Proposed development of 450/500 homes at land east of Park View; Woodstock

Representation in respect of scoping for Environmental Impact Assessment from Shipton-on-Cherwell and Thrupp Parish Council

Proposed development of 450/500 homes at Land East of Park View; Woodstock

Figure 2: Designations

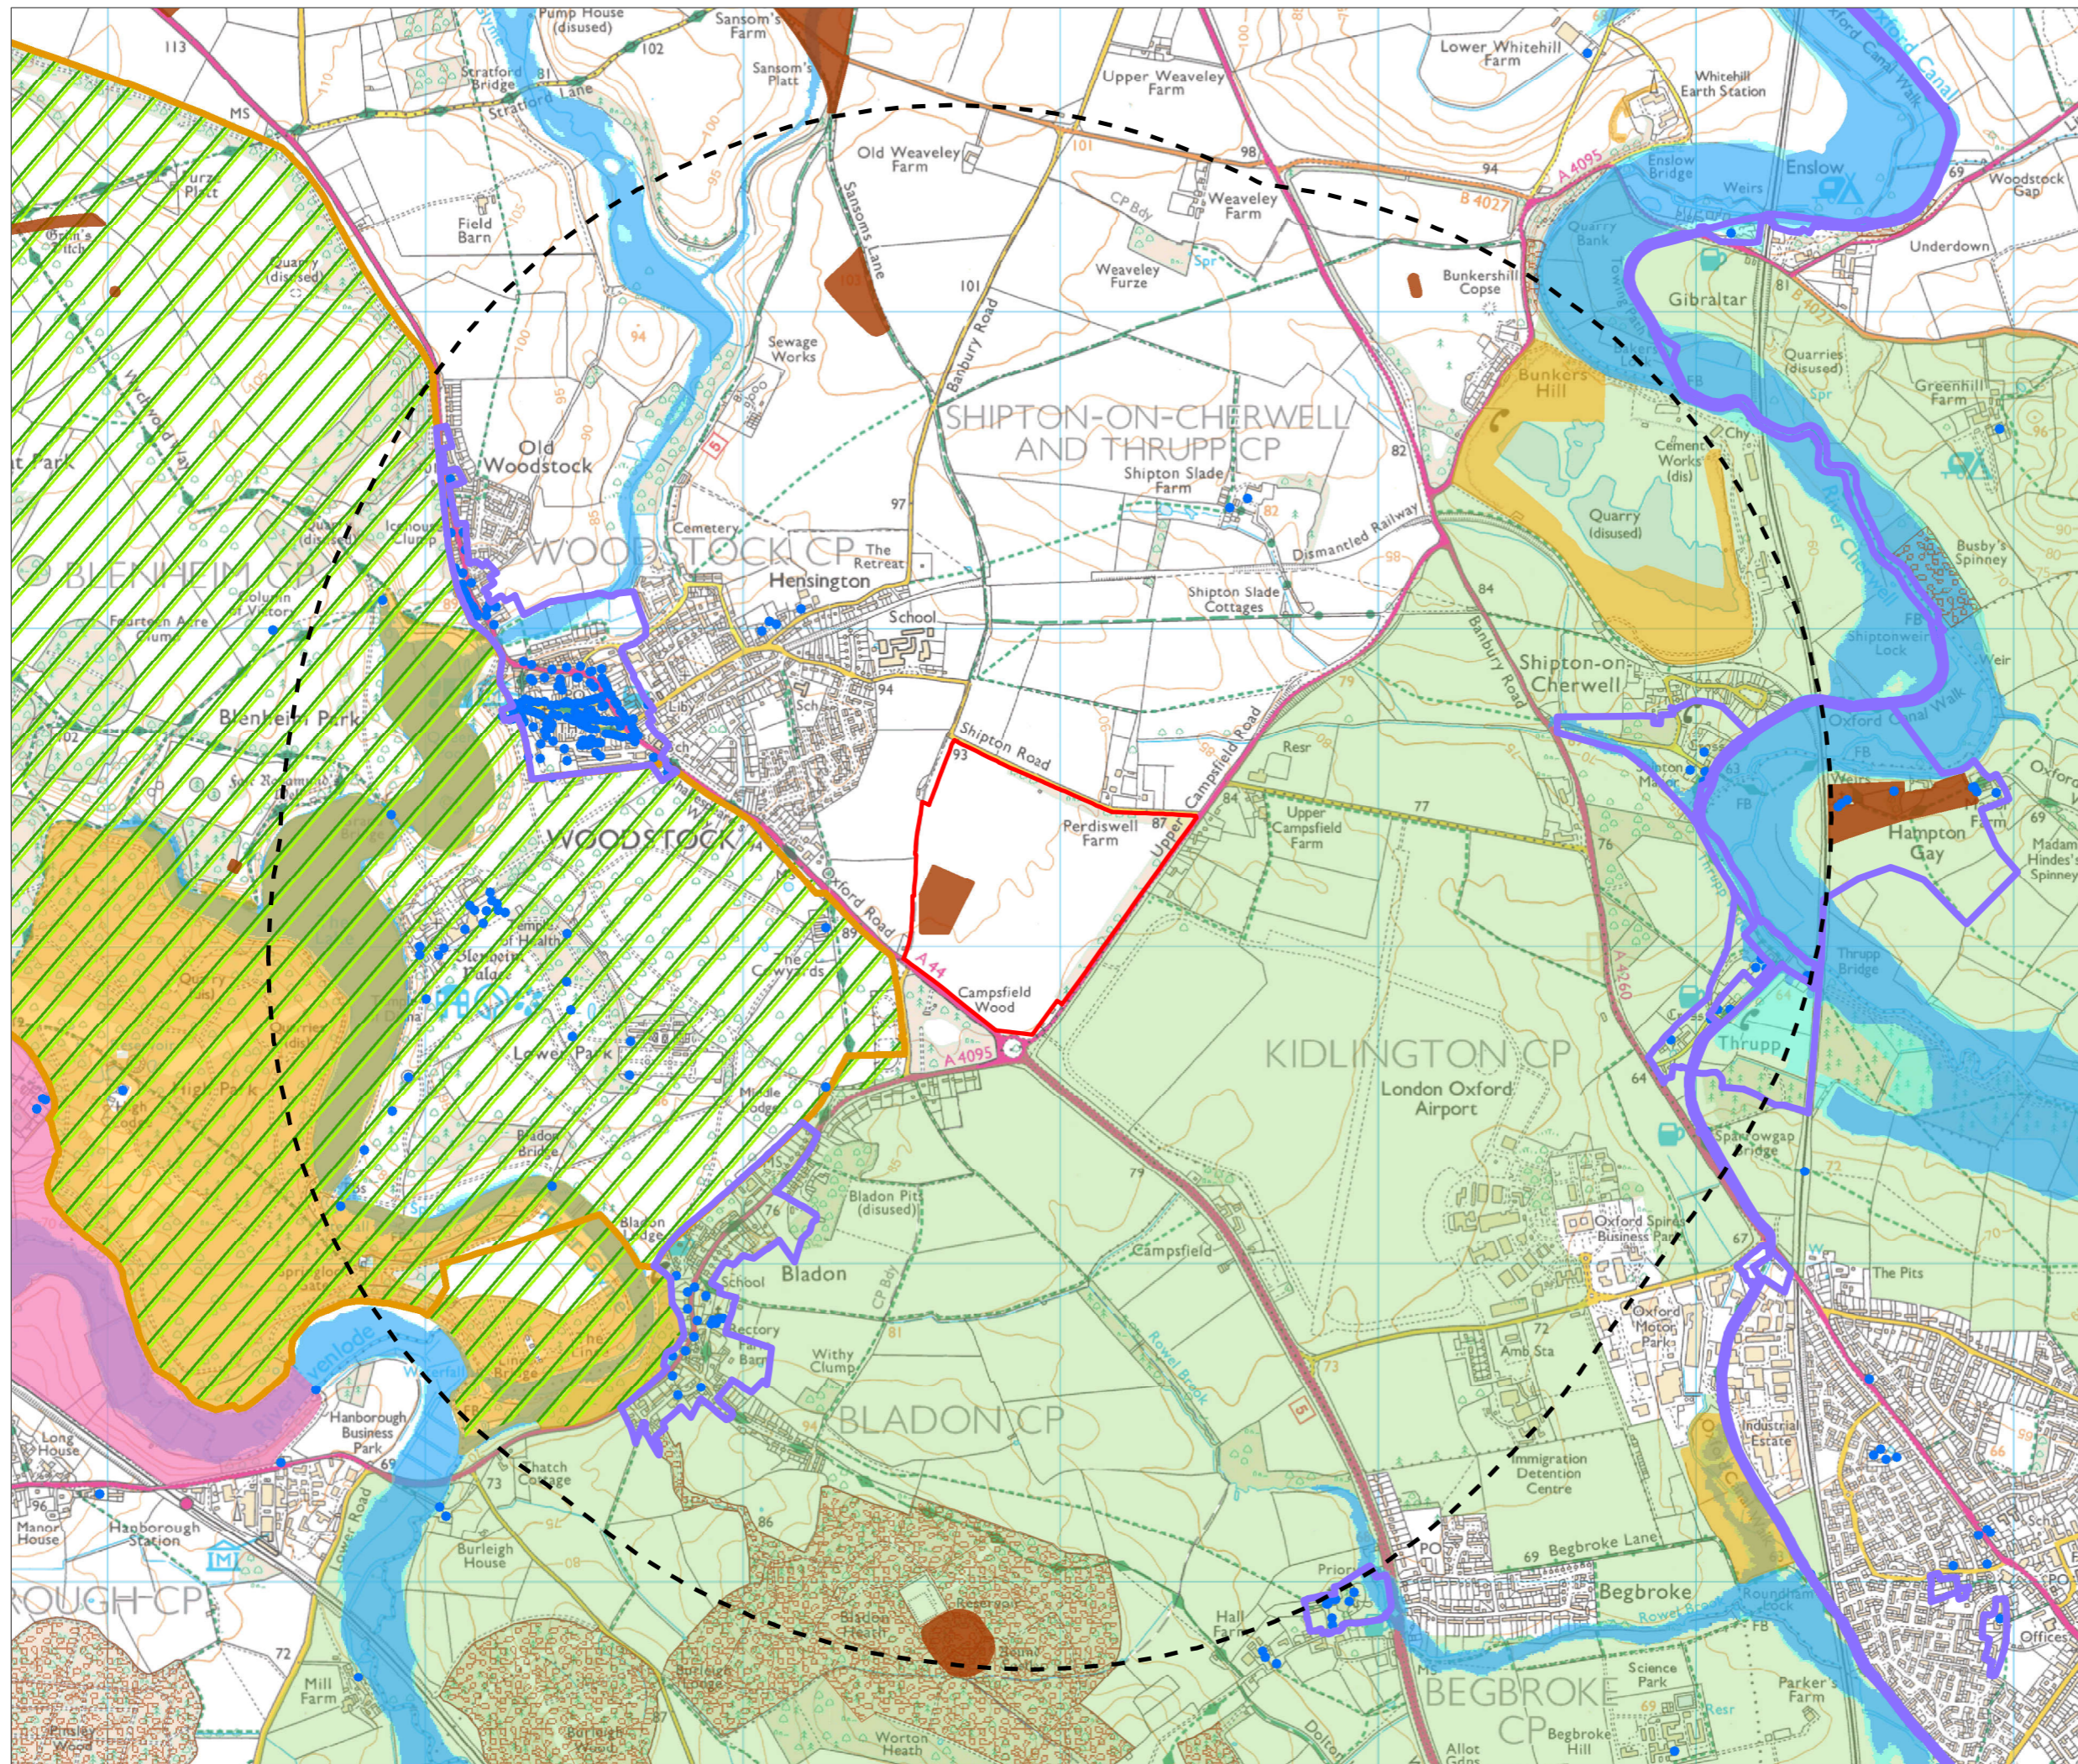
The 2km study area within the report includes the A4260/A4095 road junction but excludes Yarnton, Kidlington and the Northern Gateway area around Peartree. We view the incremental traffic impacts on these hotspots as being an essential element of the transport impact assessment.
